Port Talbot Power – ExA’s Second Round of Questions

26 March 2015

Figure 14.2.4 Port Talbot Dock simulated level time series plot for whole simulation period. Run 2 – Scenario 1 Current Operations.

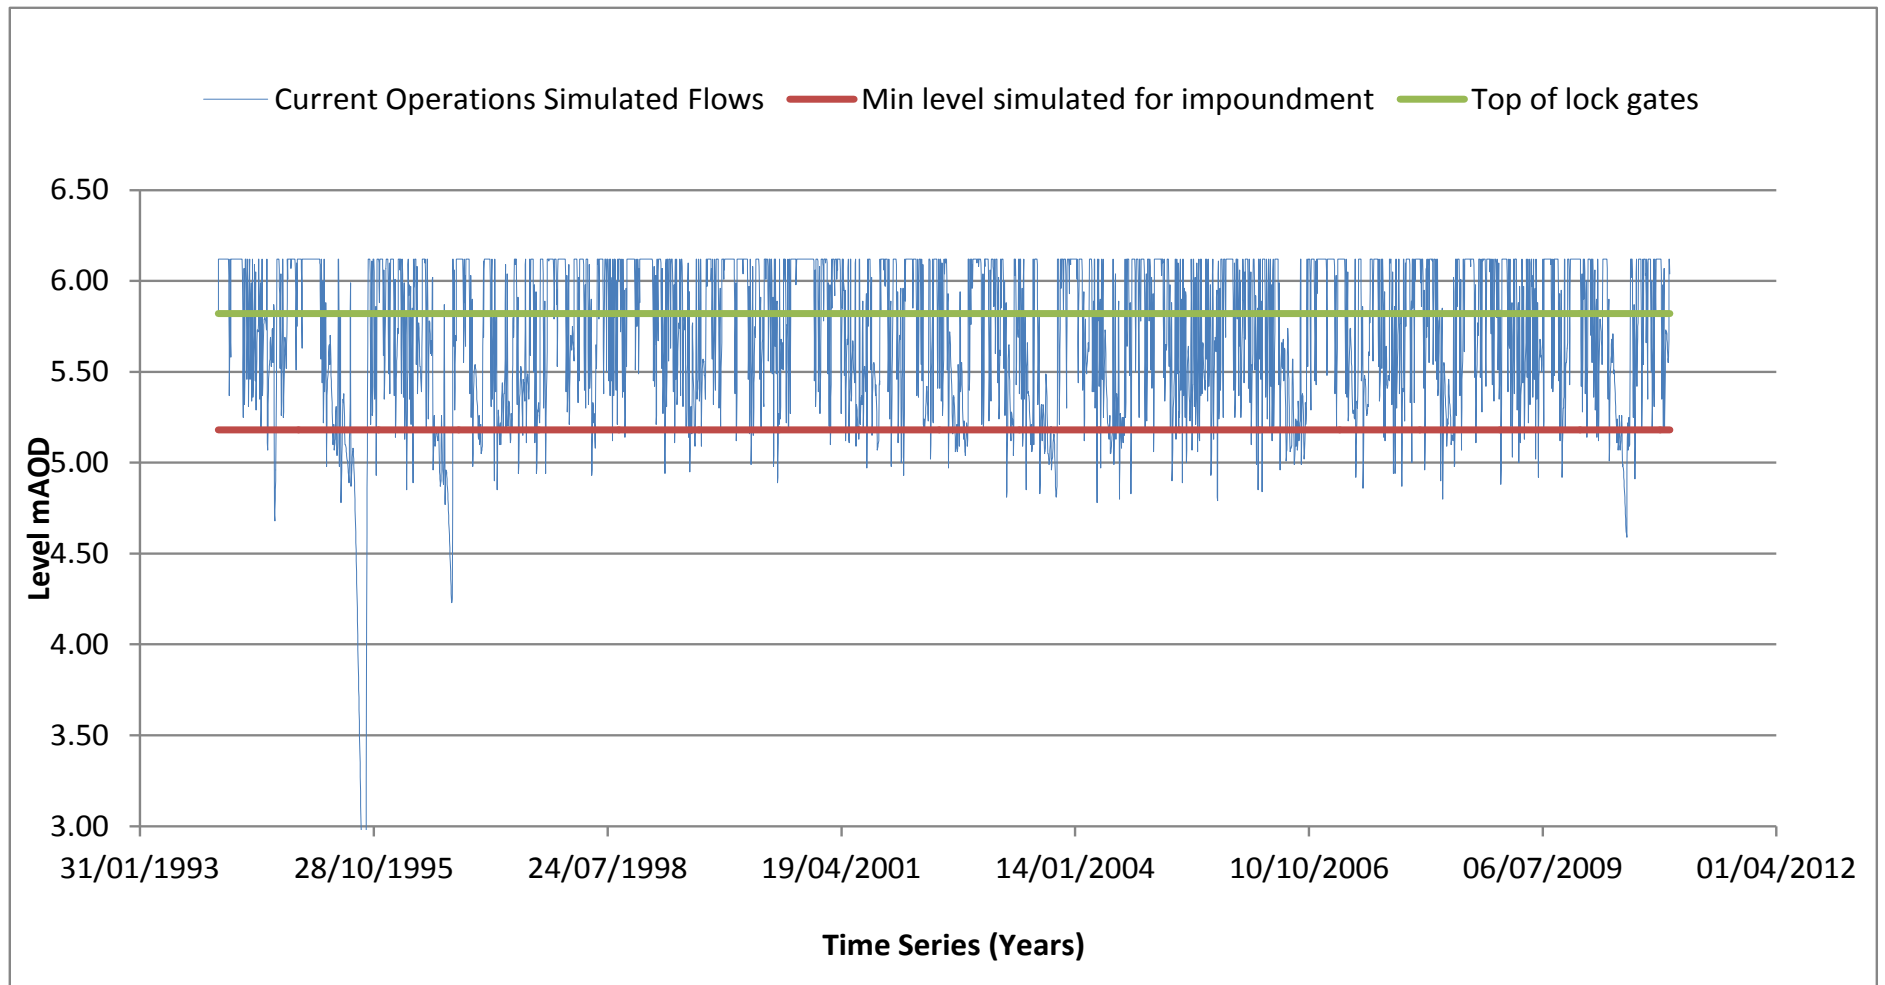
Can **Associated British Ports** provide graphical evidence to support their water level and abstraction rate requirements contained within their written representations for Deadline 4. Such should include, where relevant, the influence of the Port Talbot Dock characteristic tidal cycle and its ability to replenish water levels within the docks.
